Date: January 5, 2024

Response to Comments

Project Name: Undi Commerce Park
 Project File Number: PA 22008
 Review Completion: July 18, 2023

PROJECT LEAD: Merle  
 CHECKED BY: Tyler  
 DRAWN BY: Tyler, Alex  
 APPLICATION DATE: March 23, 2022  
 SITE APPROVAL DATE: March 23, 2022  
 REVISION DATE: January 8, 2024  
 LDA & APPROVAL:  
 AS BUILT:

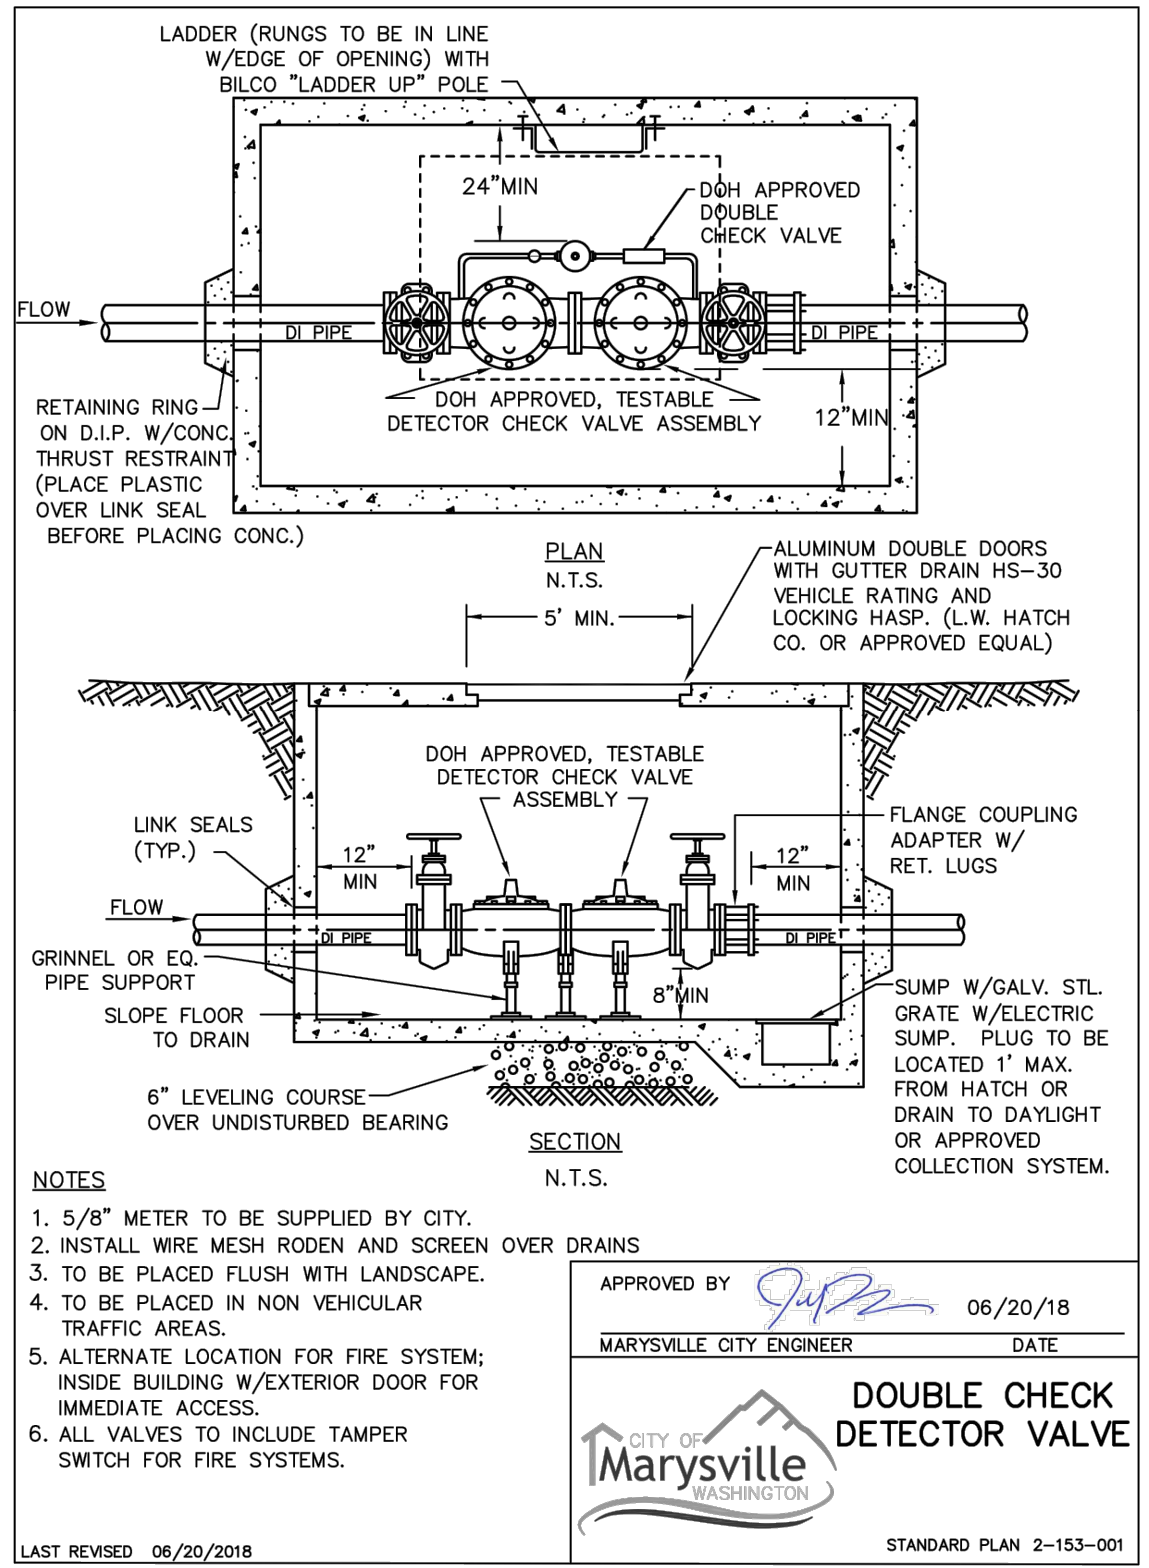
<p>18. STA 0+00 east aisle tie in change to live tap.</p>	<p>Live tap now noted.</p>
<p>19. Water main tee located between building K and D add 12" gate valve</p>	<p>Additional gate valve has been added here, sheet C8.</p>
<p>20. N=414182.5, E=1311849.3 install 8" gate valve on line going to west</p>	<p>Gate Valve has been added here on line running west.</p>
<p>21. N=414733.5, E=1311168.1, what are the locations of the 3 gate valves on the cross</p>	<p>Gate valve symbols have been added.</p>
<p>22. Locations for water services and meters both domestic and irrigation along with appropriate backflow prevention are not shown</p>	<p>These will be provided with construction plans and specific building designs. (we do not yet know where fire rooms/etc. will be located yet)</p>
<p>23. Do not see locations of fire lines or FDC. All fire lines will require a valve at</p>	<p>Thank you. Noted. Will be provided with construction plans for building construction.</p>

**SHEET**  
C9 of C13

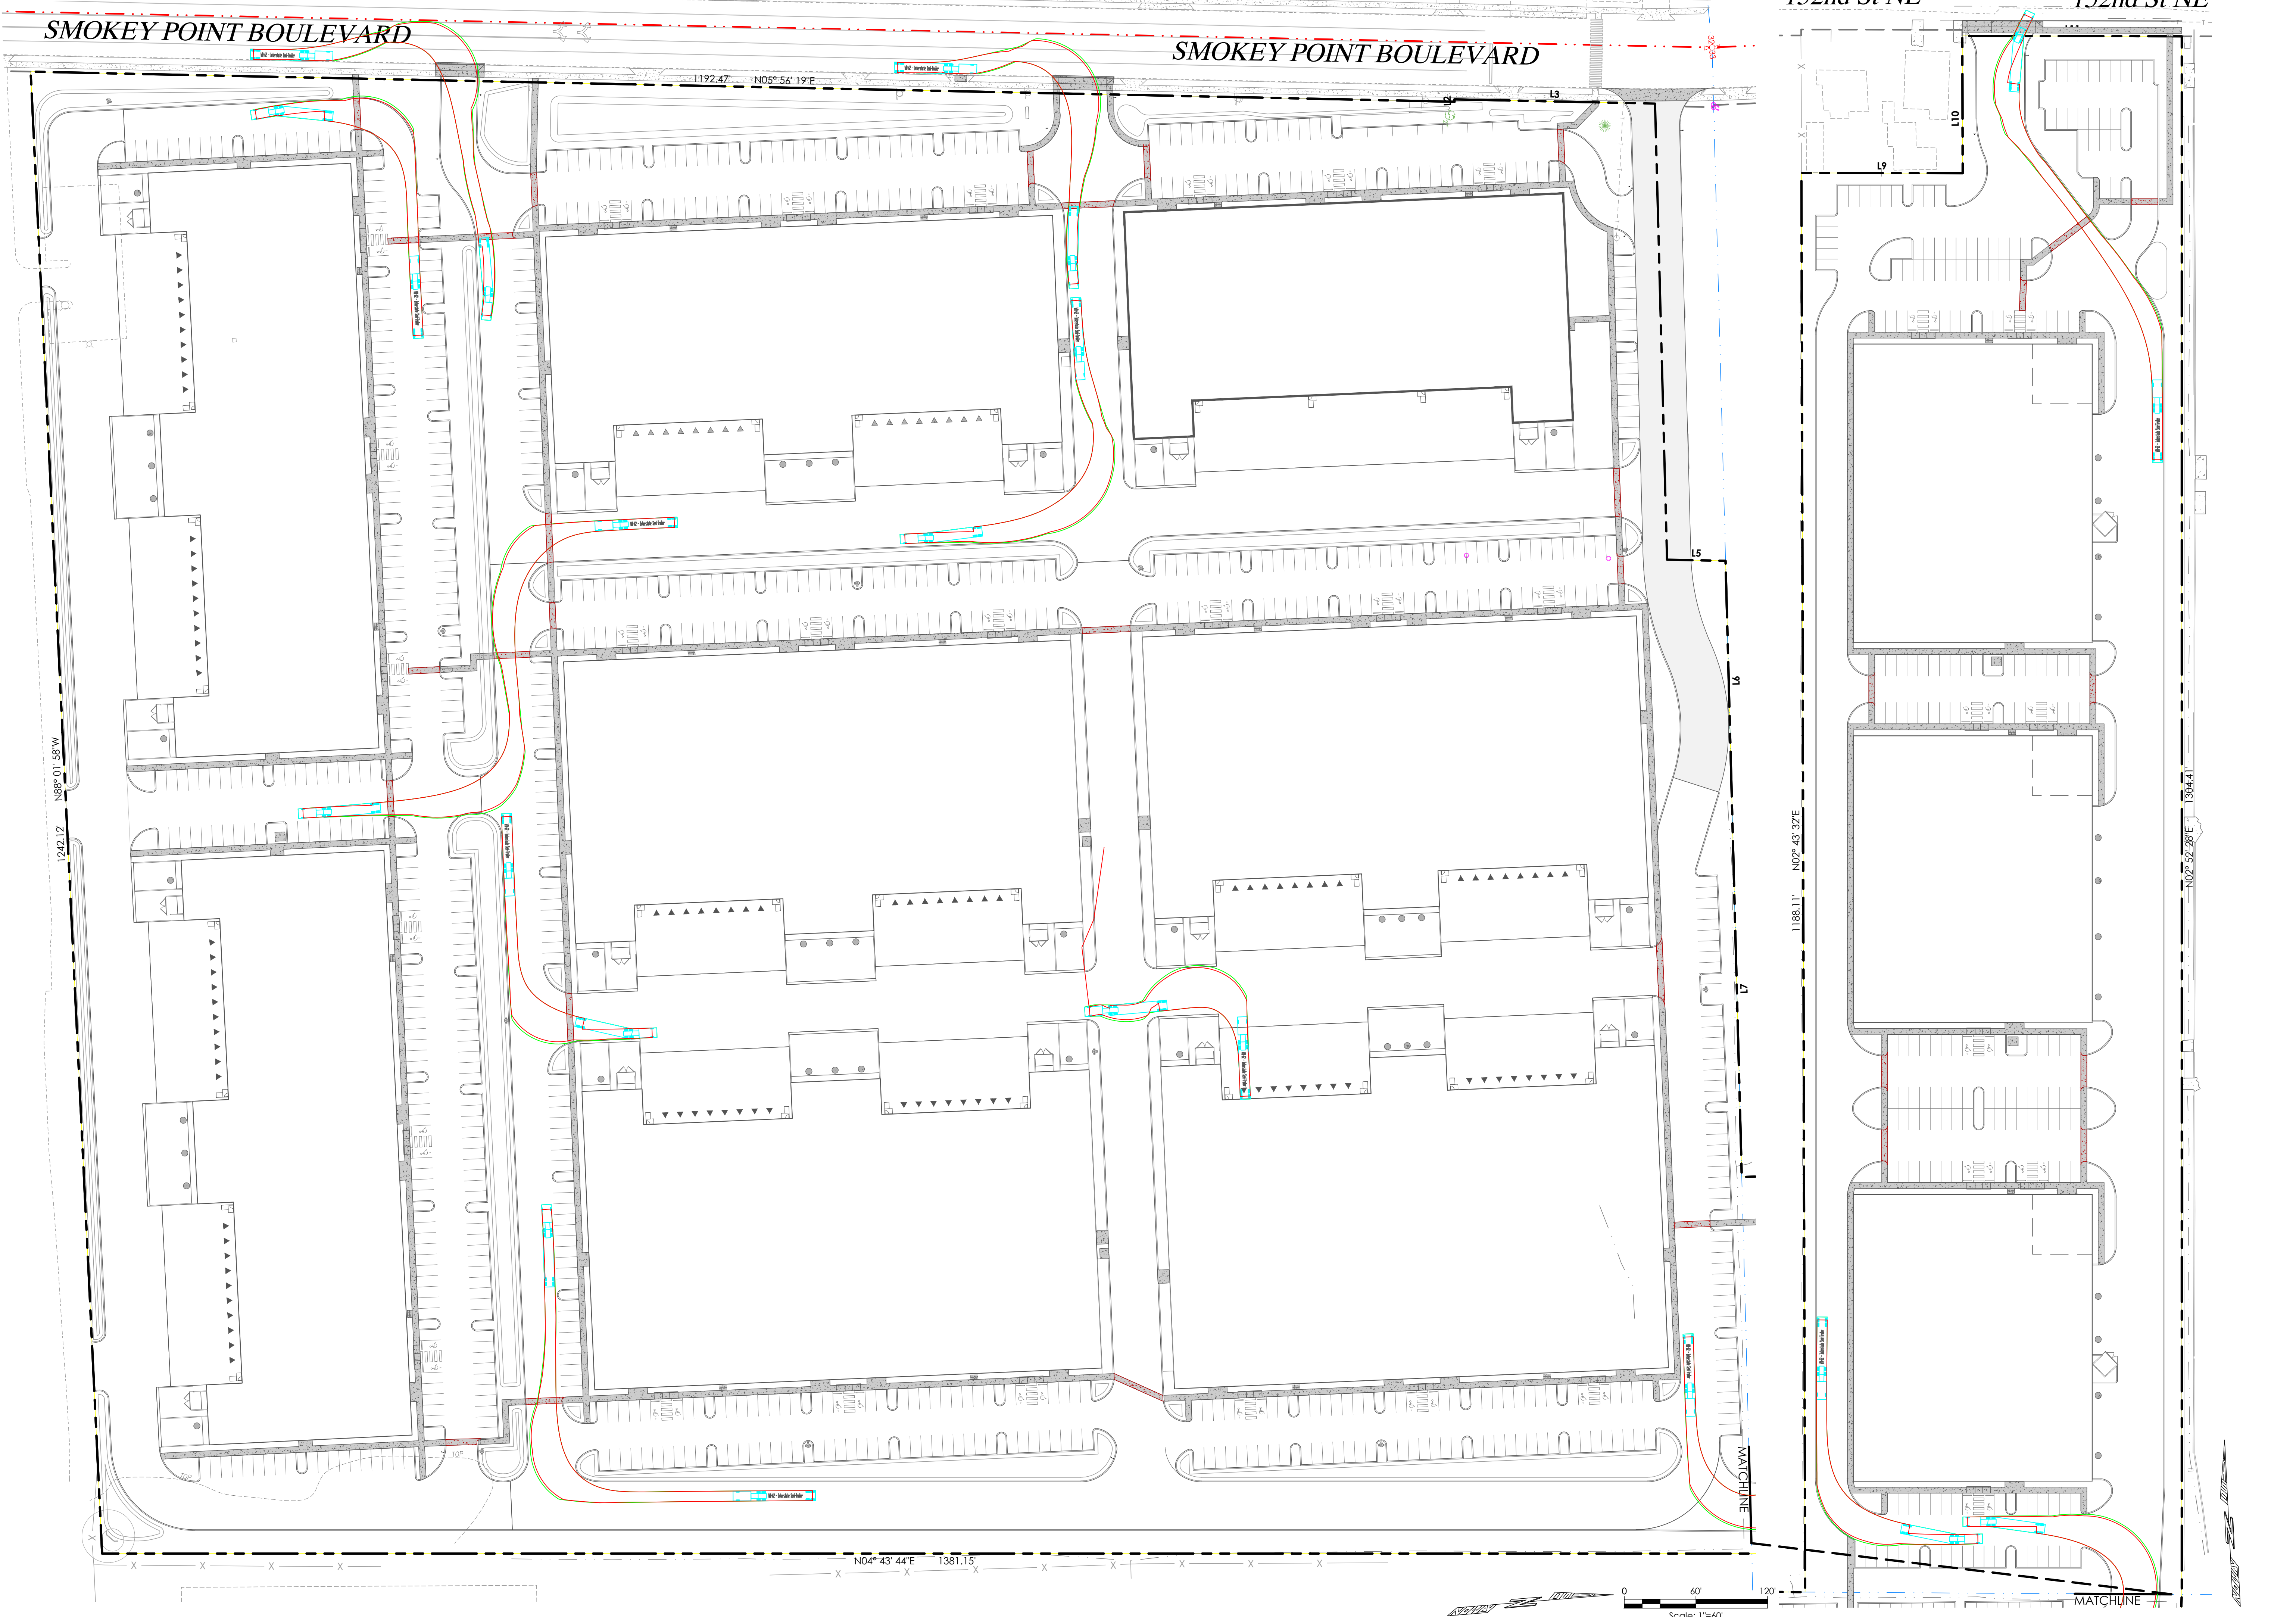
CITY COMMENTS	LAND TECH RESPONSE
<p>system is not chemically injected, a DCVA is sufficient for this application. The DCVA may be installed in an in-ground meter type box or vault. In accordance with Design Standards 2-15-001.</p>	
<p>15. On-site inspections are to be performed by the City of Marysville Cross Connection Control Specialist at rough-in and final. 48 hours' notice is required, prior to inspection.</p>	<p>Thank you. Contractor will coordinate inspection scheduling.</p>
<p>16. Testing of all backflow prevention assemblies, by a Washington State Certified Backflow Assembly Tester, is required prior to occupancy use per MMC 14.10.120. Test report shall be forwarded to the City of Marysville Water Quality Office, prior to occupancy.</p>	<p>Thank you. Noted.</p>
<p>Public Works - Operations Reviewer: Kim Bryant, Water Operations Supervisor Tim King, Utility Construction Lead II</p>	
<p>17. Water details not shown.</p>	<p>Water details have been added as Sheet C9.</p>
